From: PHILIP HAILEY [REDACTED]
Sent: 16 April 2018 12:45
To: Simon Davis
Cc: Pagham Parish Council
Subject: Re: 251 Pagham Road Landscaping - Application P/1/18/DOC

P/1/18 Discharge of condition 21

Thank you for sending me revised details in relation to discharging condition relating to Landscape Planting (condition 21).

drawing title	Landscape General Arrangement (East)				
drawing no.	1896-TF-00-00-DR-L-1002				P03
scale	1:250 @ A1	date	28.09.17	drawn by	AC
				checked by	AC

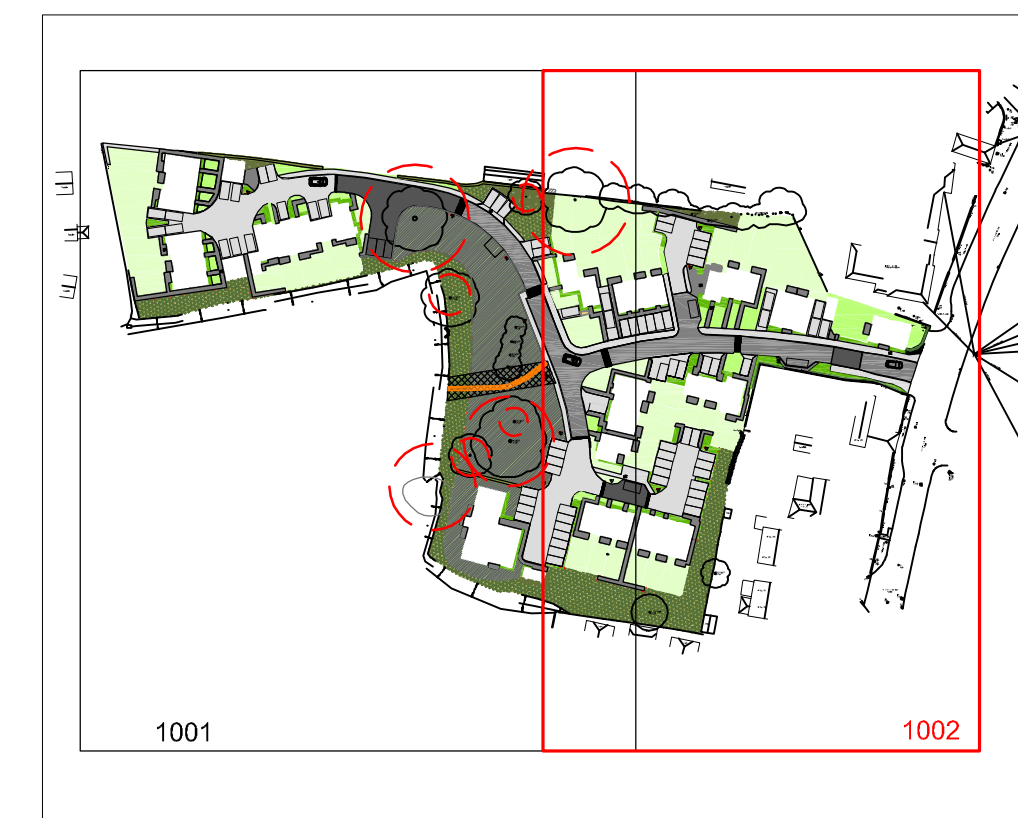
i) The trees proposed are deciduous trees which will mean that when the leaves drop the new development will be fully visible to the existing properties in Pagham Road. The visual barrier cannot therefore be considered appropriate unless tall evergreens are introduced or the tree planting is significantly increased.

ii) It would appear that there is no plan submitted for the maintenance of these areas and much of the planting proposals are ephemeral. What is the plan for future replacements maintenance and who will be responsible?

iii) It is also not clear on the maturity/height of the initial planting as this would have significant implications to the initial visual screening from year 1.
